Brittany Golding
Planning Group
NSW Department of Planning, Housing and Infrastructure (DPHI)

Subject: Taronga Tin Mine (SSD-74389710) Environmental Impact Statement

Attachment A

Detailed advice to DPHI Planning & Assessment regarding the Taronga Tin Mine EIS

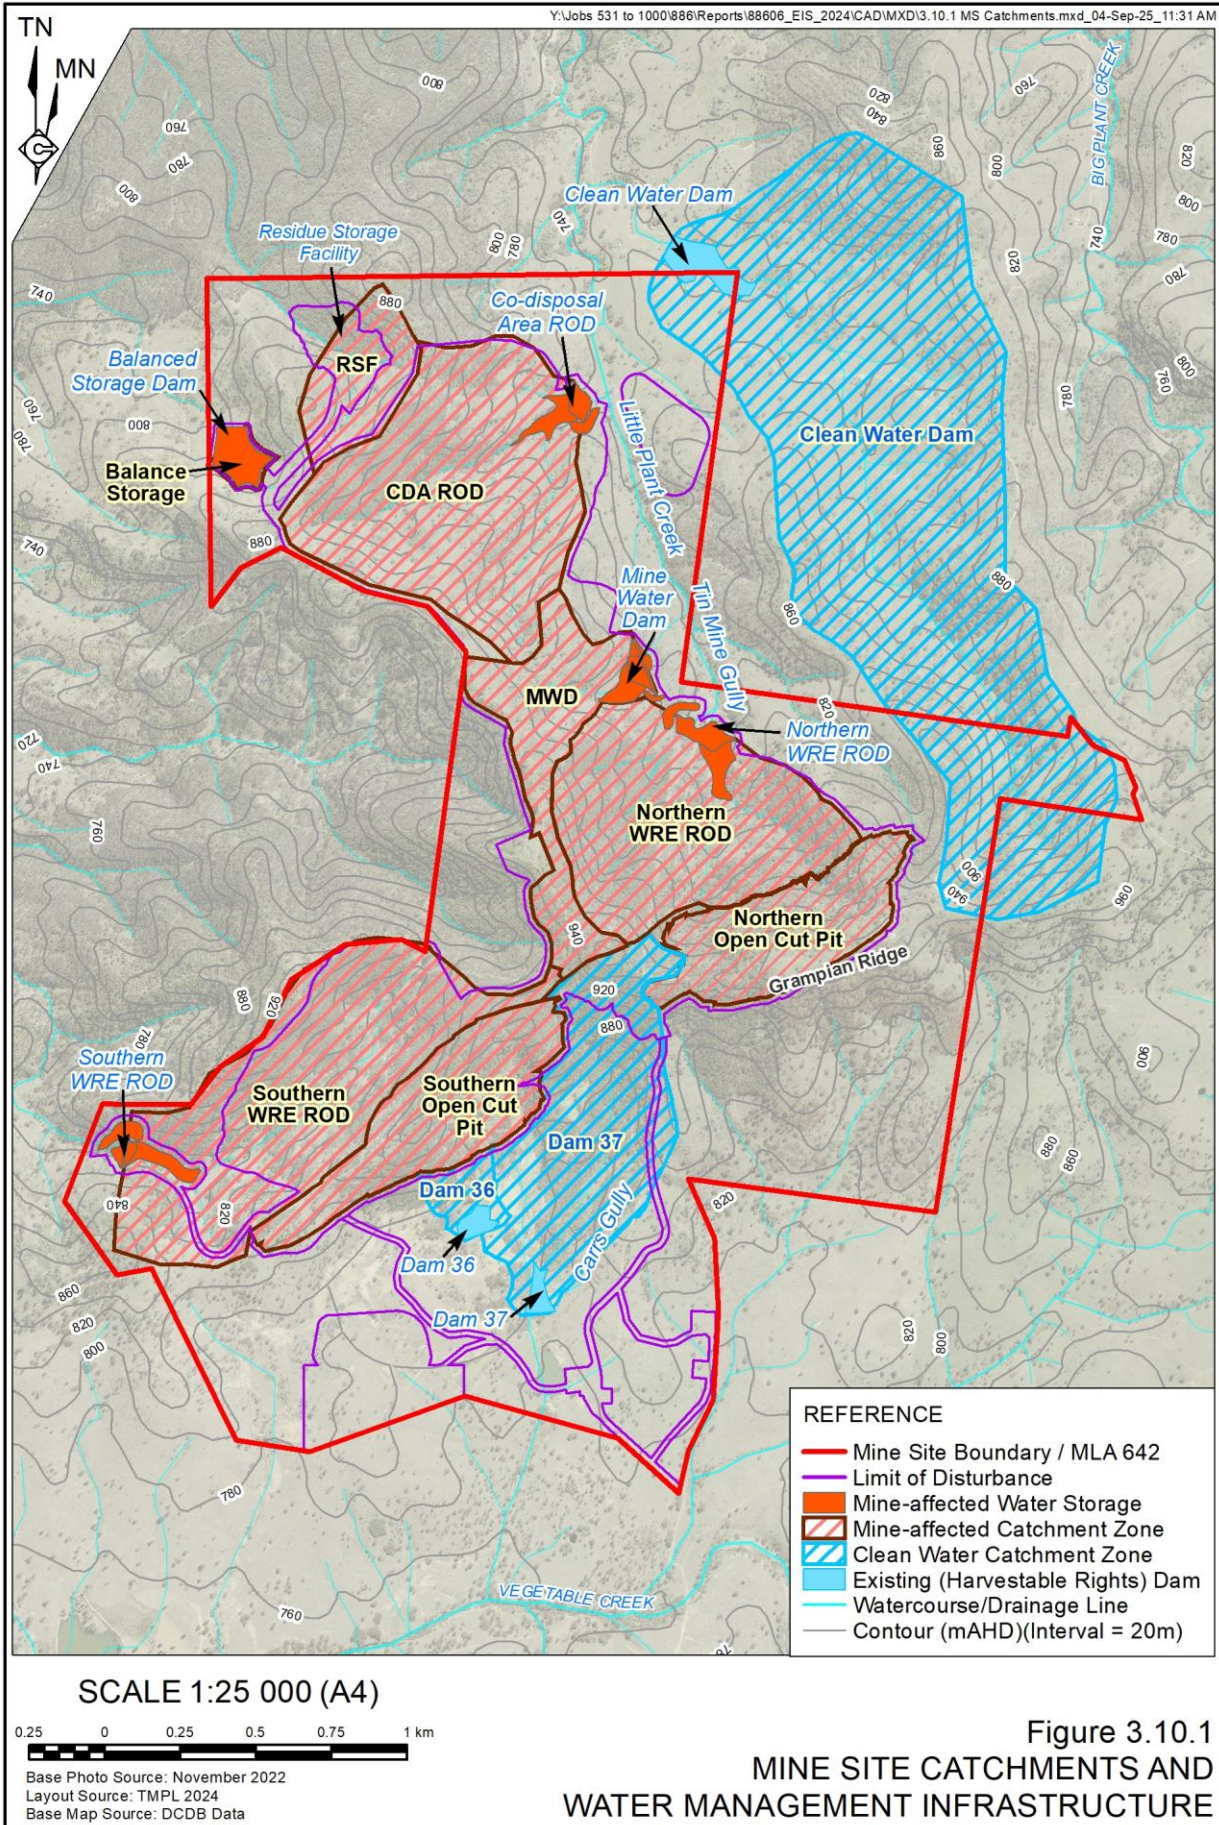
That DPHI requests the proponent to review the ability for all works capturing water within the mine affected catchments to meet the excluded works requirements in Schedule 4, Part 7 of the Water Management (General) Regulation 2025 (WM Reg).

The mine site water management infrastructure indicates a number of dams to be used to capture water from the mine affected catchments and the proponent references the use of excluded work provisions under the WM Reg. It is unclear how the water captured and removed in the open cut pits is being considered, noting to meet the excluded work provisions the work must be a dam. Further information on the application of excluded works is accessible in a factsheet which is accessible at:

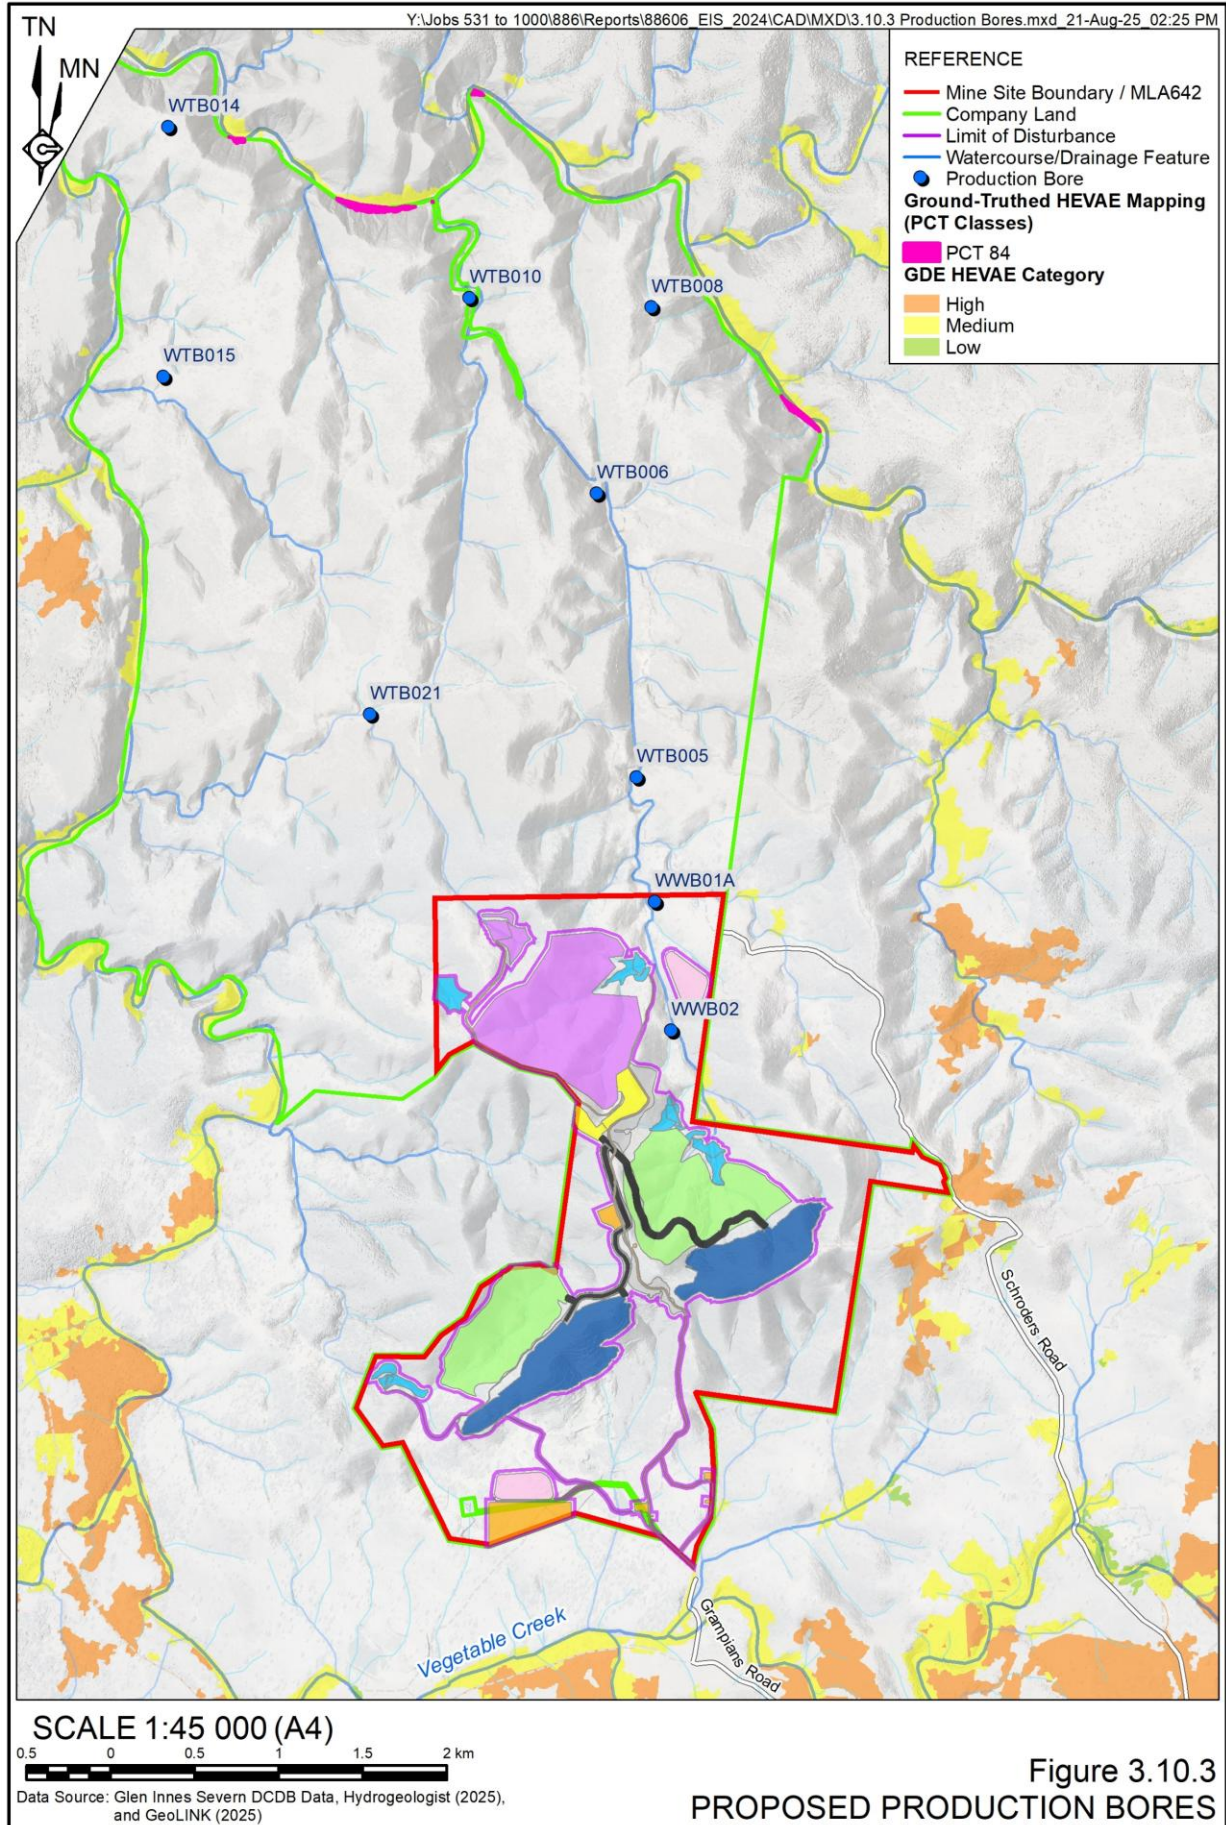
- Provide a map depicting the location of the proposed water pipelines from the borefield and identify where they are to be above or below ground.
- Confirm for any trenching activities for pipeline installation if groundwater is to be intercepted, and if so, quantify the maximum annual groundwater take and the requirement for licensing.

Insufficient information is provided to understand the location of all water supply works (pipelines) and the potential for aquifer interference during construction. Additional information is required to enable exclusions to apply from a water supply work approval under the *Water Management Act 2000* and to determine the requirement for water licensing for groundwater take.

That DPHI requests the proponent to review the locations of all proposed bores to meet the distance rules defined in the Water Sharing Plan for the NSW Murray Darling Basin Fractured Rock Groundwater Sources 2020.

A review of the proposed bore locations provided in the EIS documentation indicates a number may not meet the distance rule of 40 m from the high bank of a river. It is recommended the bores be located to meet this distance rule and provide a revised map where necessary.
